Statement of Common Ground with Beverley and North Holderness Internal Drainage Board (draft)

Revision ~~23~~ (tracked)

~~September~~October 2025

- 1.1.1 This Statement of Common Ground (hereafter referred to as the 'SoCG') has been prepared to support the Examination of the Development Consent Order (DCO) application (the 'DCO Application') for Peartree Hill Solar Farm (the 'Proposed Development').

Temporary bridges - General arrangement

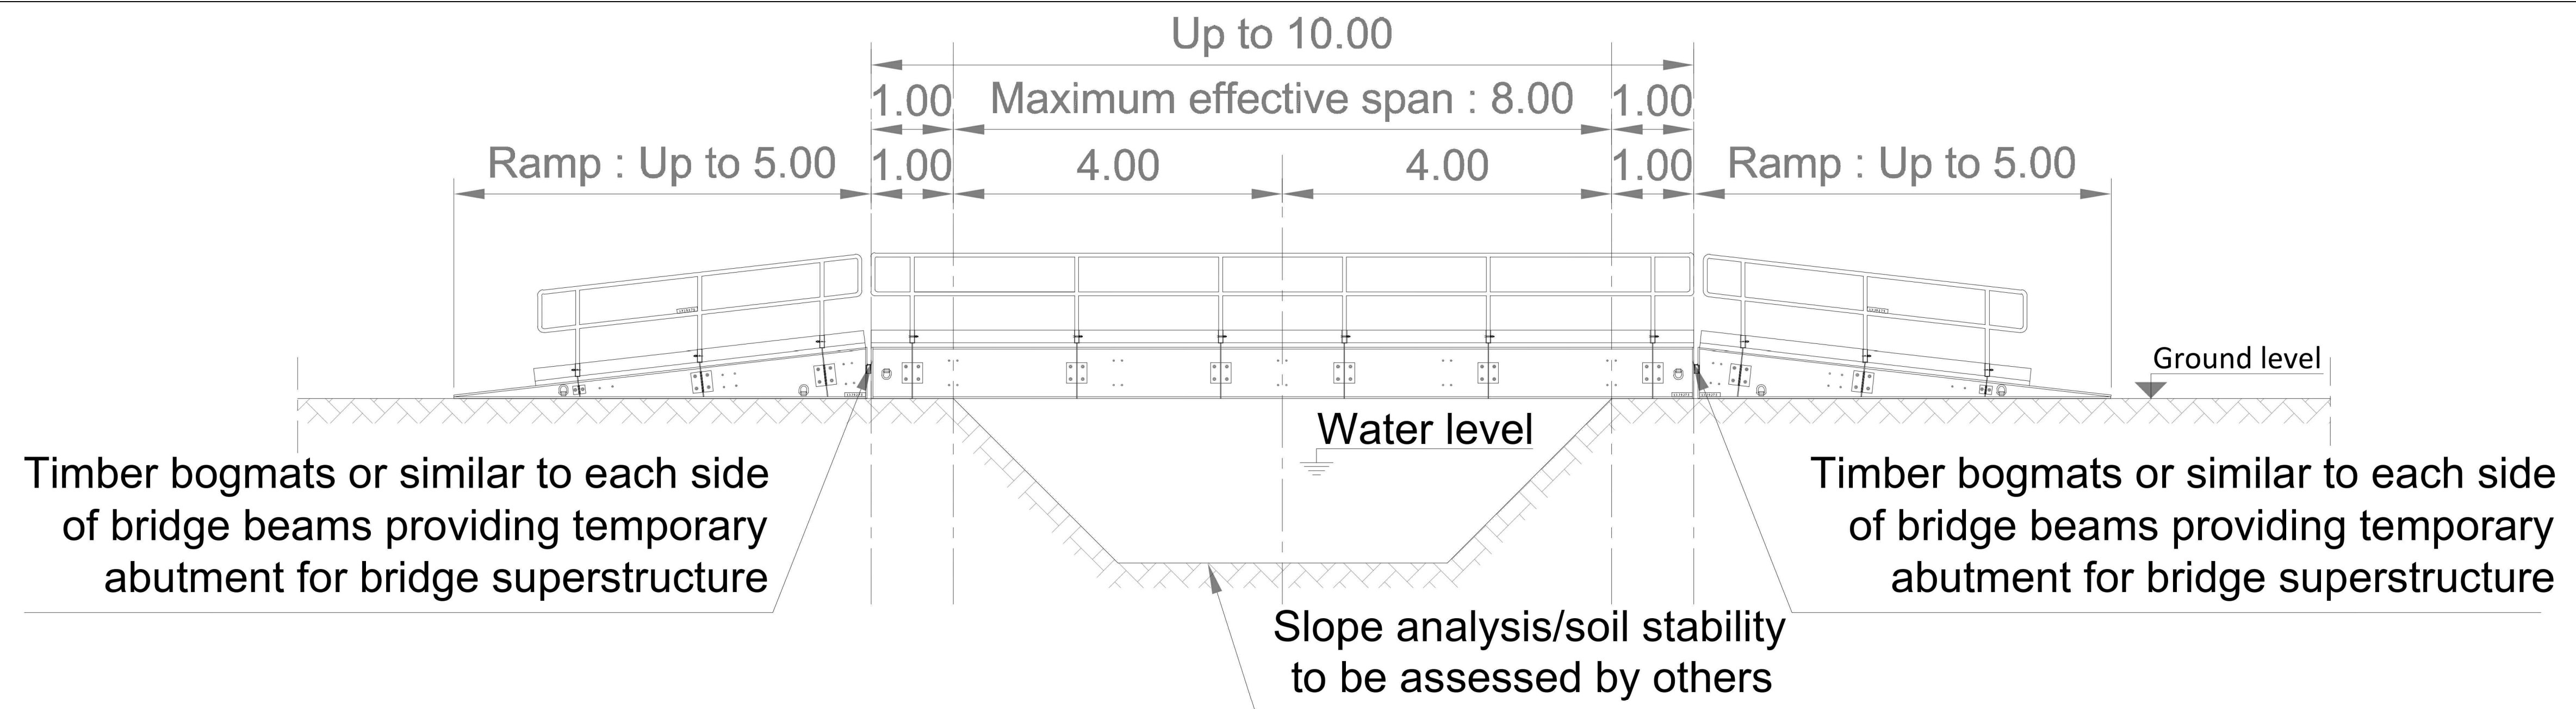
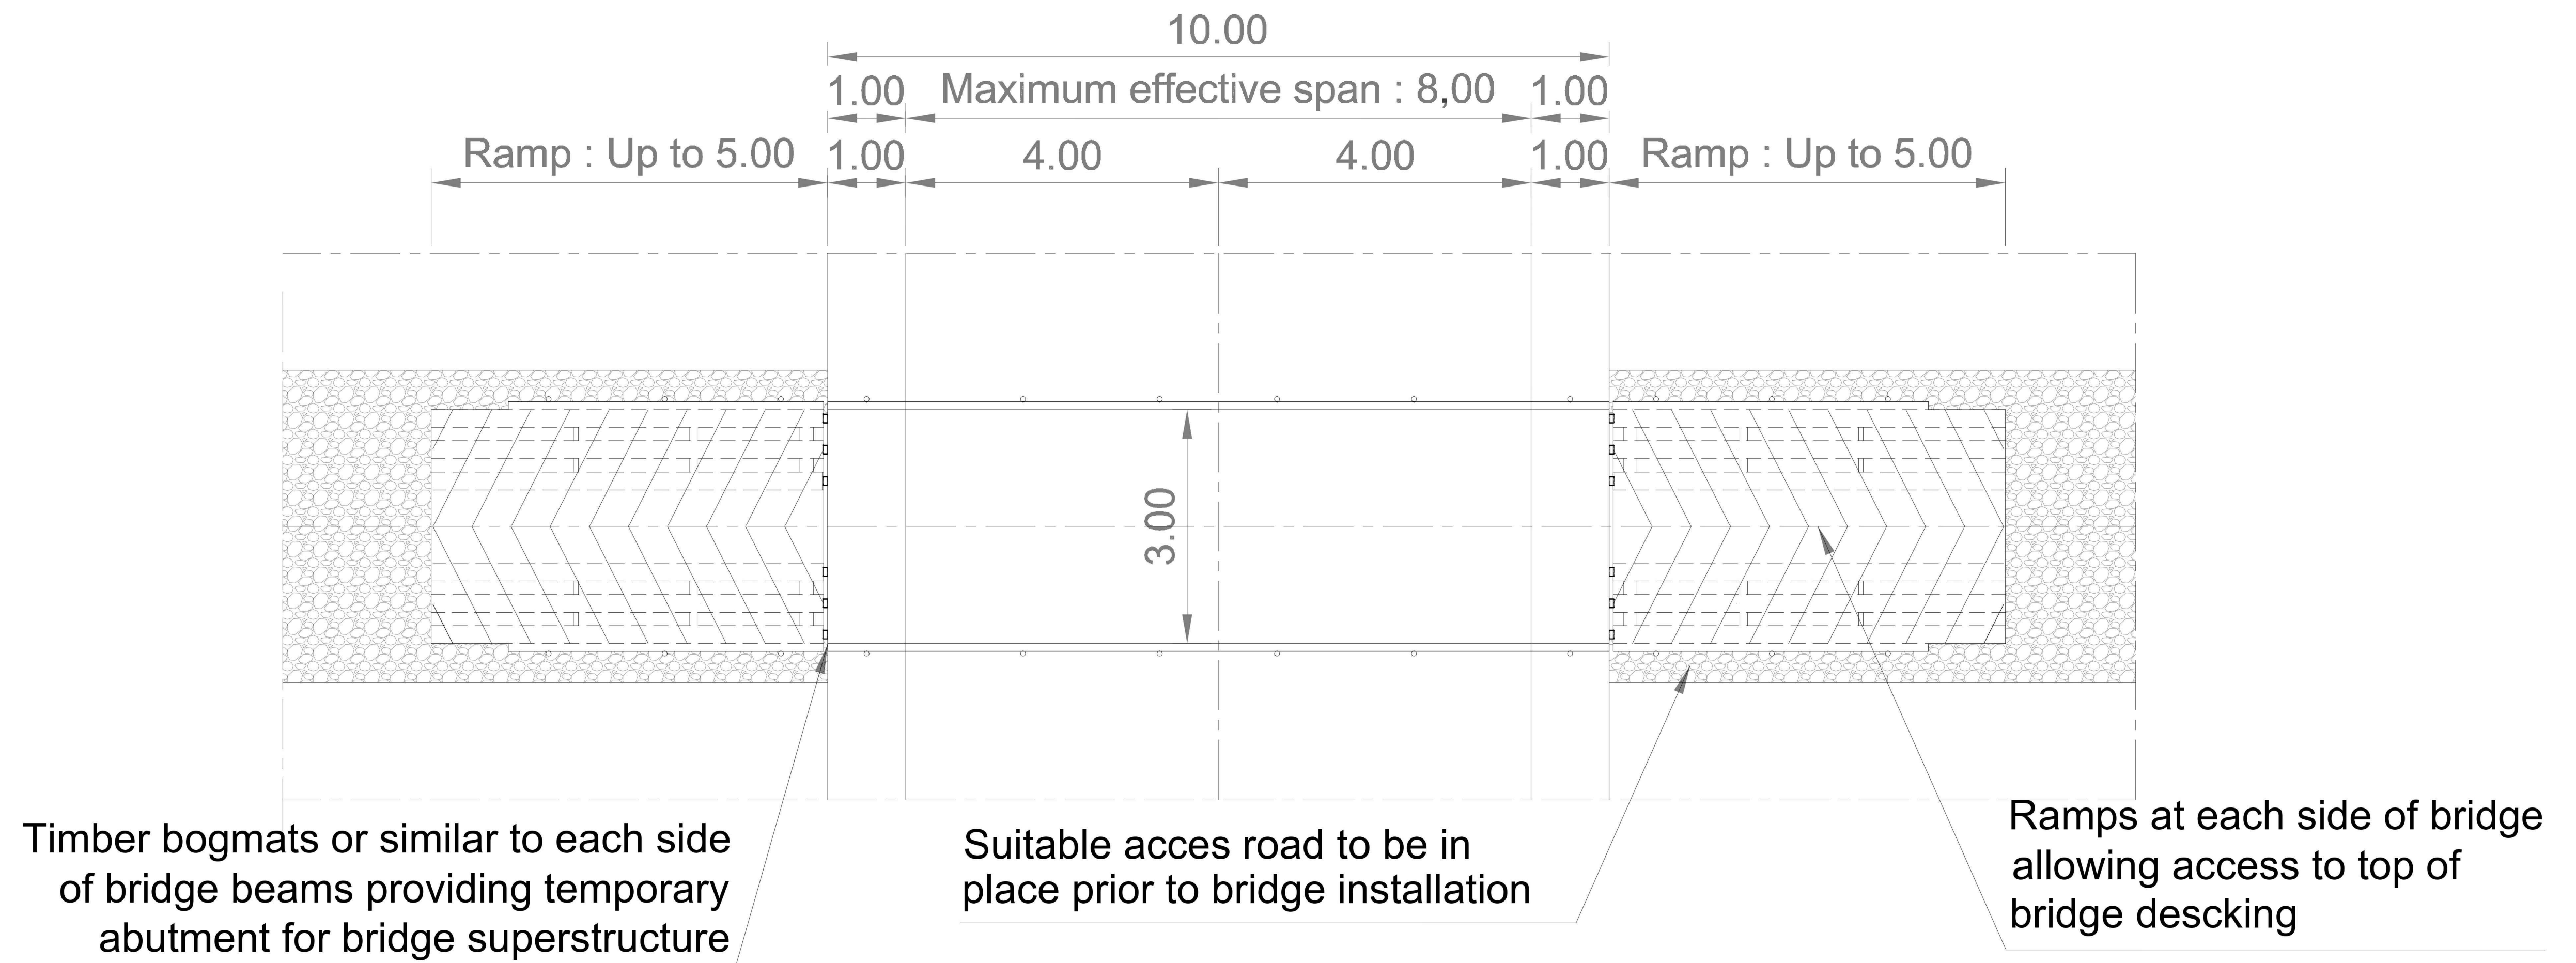
Ref	Topic	Beverley and North Holderness Internal Drainage Board Position	Applicant's Position	Status
		"permeable" and not requiring a drainage strategy-, whereas if Type 1 materials or other impermeable materials are used, this is viewed as "impermeable" and requiring a drainage strategy.	strategy for the relevant works to the Beverley and North Holderness Internal Drainage Board. The updated document is submitted at Deadline 3. The Applicant will continue to liaise with the Board on this matter.	
IDB03	Bridge/ culvert crossings over watercourses <i>Hydrology and Flood Risk</i>	In its relevant representation [RR-004], Beverley and North Holderness Internal Drainage Board requests that details of any bridge/culvert crossings over any watercourses within its district will need to be discussed and agreed with the Board.	<p>The Applicant agrees to this request. It is the Applicant's intention to utilise existing culvert crossings and/or bridge structures where possible. Pre-construction structural surveys will be undertaken to determine the most appropriate crossing at each location (it is expected that the pre-construction surveys would result in the number of new crossings required to be lower than is shown on ES Volume 3, Figure 3.6: Indicative Culvert Crossing Points [APP-060]). Crossing design would be controlled by the protective provisions within Part 3 of Schedule 12 to the Draft DCO [EN010157/APP/3.1 Revision 4], which require plans to be submitted to the Board for approval at the detailed design stage.</p> <p>ES Volume 4, Appendix 5.6: Flood Risk Assessment [EN010157/APP/6.4 Revision 3] and ES Volume 4, Appendix 5.5: Water Framework Directive Screening and Scoping</p>	Agreed

Ref	Topic	Beverley and North Holderness Internal Drainage Board Position	Applicant's Position	Status
			report [EN010157/APP/6.4 Revision 2] have been updated to clarify the approach to watercourse crossings and are submitted at Deadline 1.	
IDB04	Cables <i>Hydrology and Flood Risk</i>	In its relevant representation [RR-004] , Beverley and North Holderness Internal Drainage Board requests that the Applicant seek prior written consent from the Board if proposing to insert a cable under a watercourse within the Board's district. The Board would prefer for any cables crossing watercourses to be laid above any existing culverts so that they do not affect water flows and do not therefore require the Board's consent in terms of the cables themselves. If this is not feasible, directional drilling must be used. The Board will not accept open cut crossings.	<p>The Applicant agrees to this request. As set out in the Outline Construction Environmental Management Plan [EN010157/APP/7.2 Revision 2] the Applicant proposes to use horizontal directional drilling (HDD) or crossings above watercourses. The Applicant is not proposing to use open cut methods to cross Board-maintained watercourses.</p> <p>The Applicant notes the need to seek written approval from the Board prior to installing cables over or HDD-ing under watercourses within the Board's district and this is secured in the protective provisions for the benefit of the Board set out in the Draft DCO [EN010157/APP/3.1 Revision 4].</p>	Under discussion
